WEST SUSSEX COUNTY COUNCIL CONSULTATION

TO:	Arun District Council FAO: Anita Gardner
FROM:	WSCC - Highways Authority
DATE:	24 October 2019
LOCATION:	Broomhurst Lodge Lyminster Road Littlehampton BN17 7QQ
SUBJECT:	LY/11/19/PL New access construction to serve as an access for Broomhurst Farm & its residents.
DATE OF SITE VISIT:	n/a
RECOMMENDATION:	More Information
S106 CONTRIBUTION TOTAL:	n/a

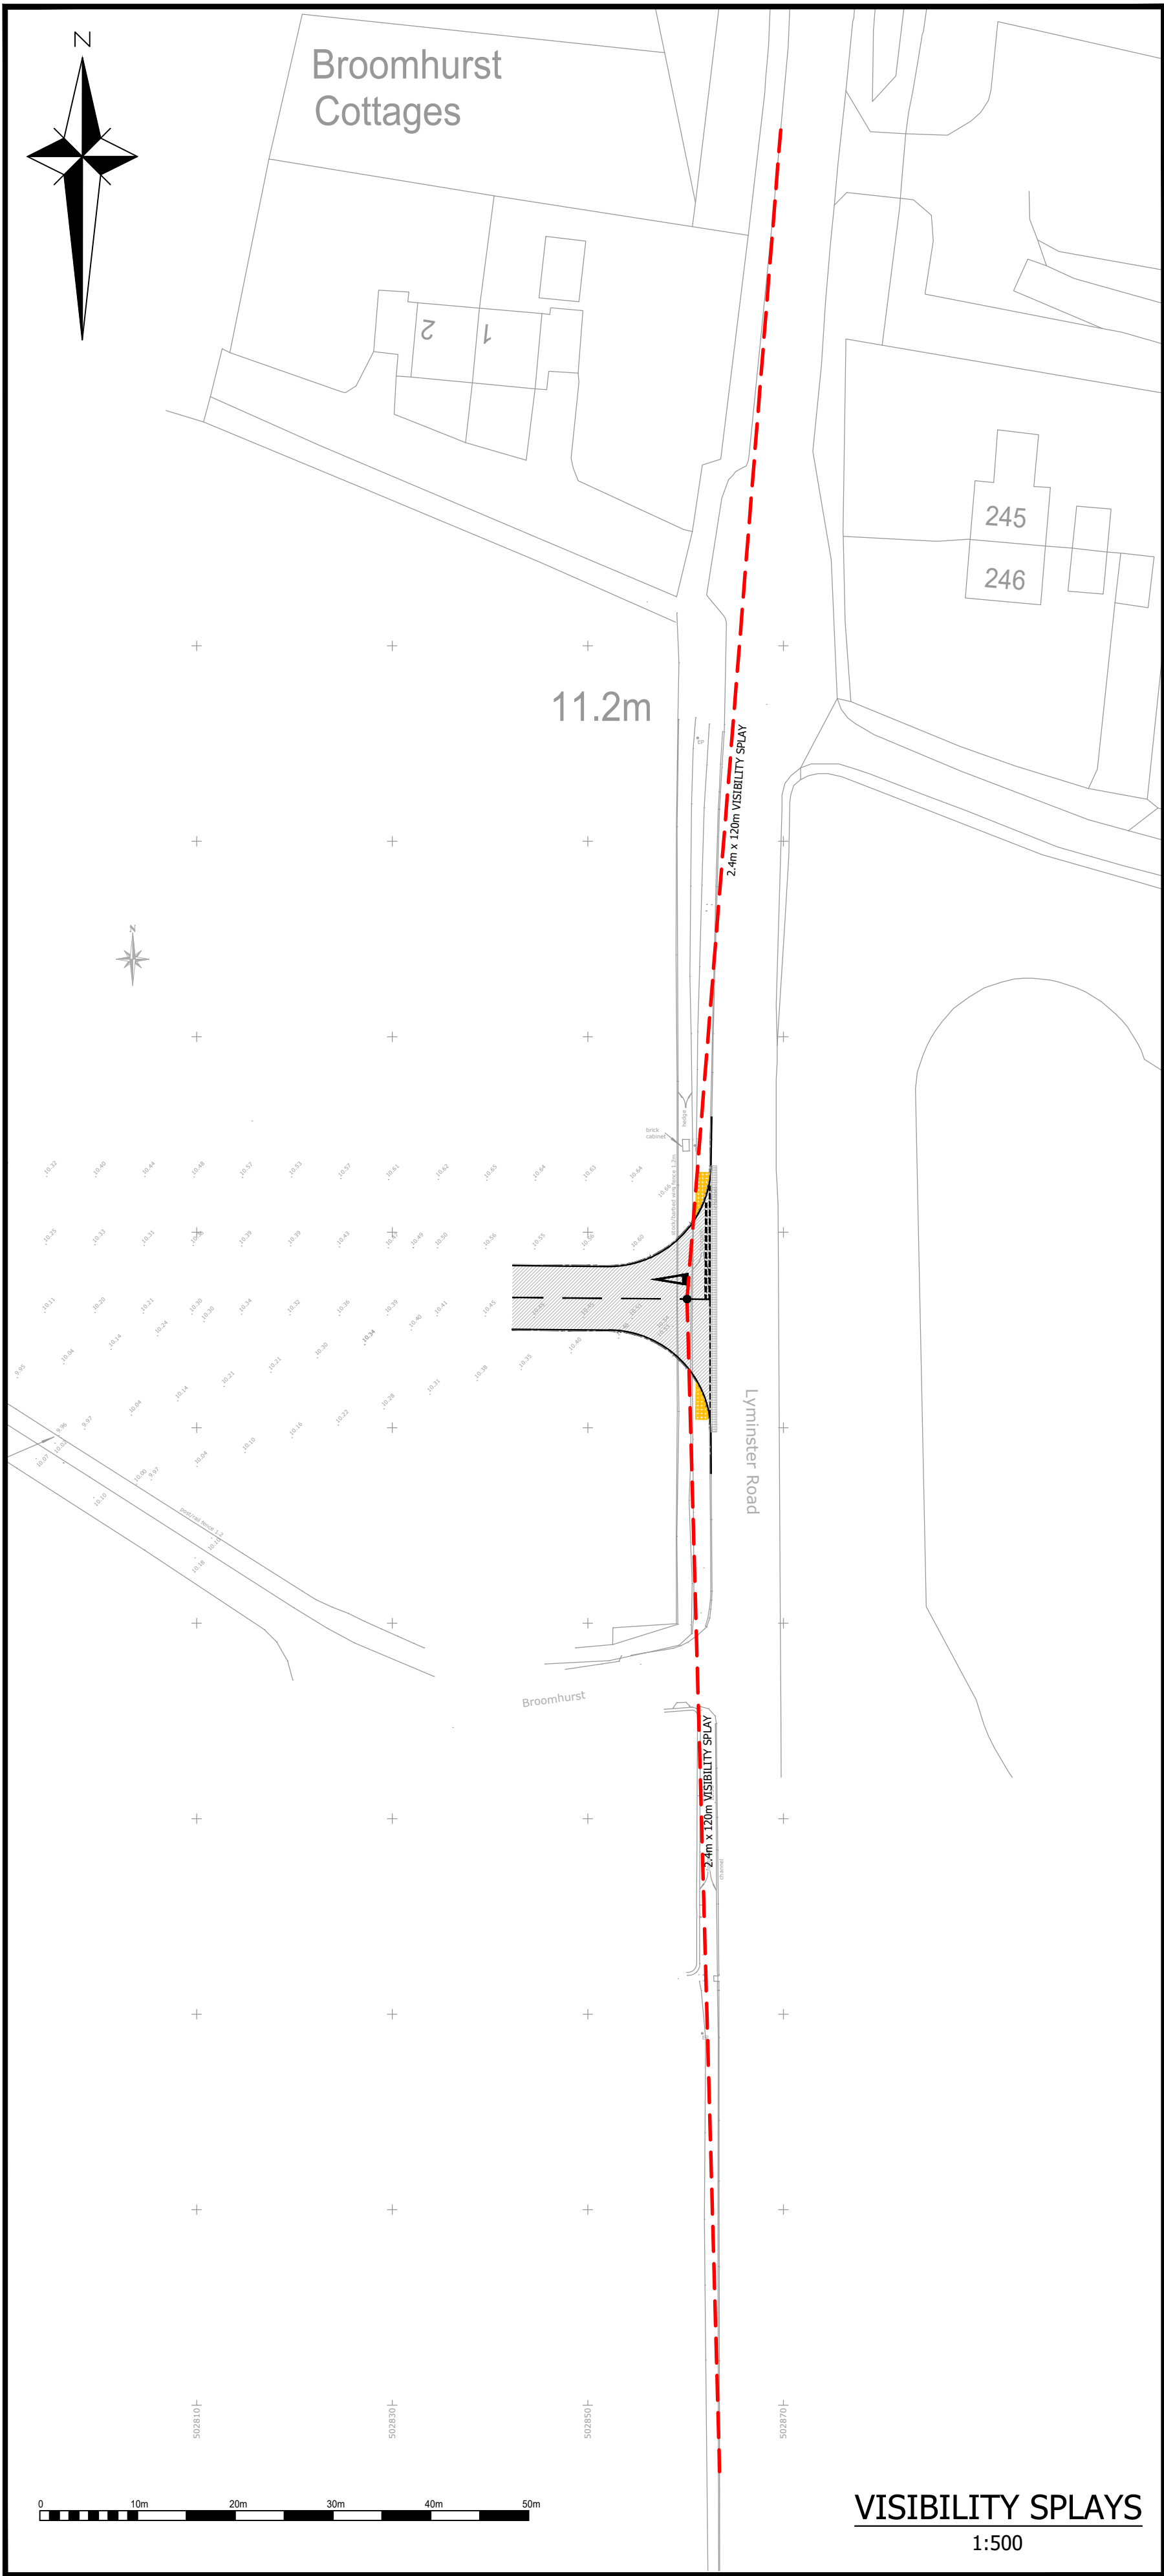
The applicant has provided plans demonstrating the minimum requirement for visibility as per Design Manual for Roads and bridges (DMRB) of 2.4 x 120 metres. The LHA however recognise that visibility in this area is greater than that proposed.

The applicant has demonstrated swept path tracking in accordance with WSCC guidance. This shows that farm traffic would have the ability to enter and exit the proposed access without detrimentally affecting highways safety.
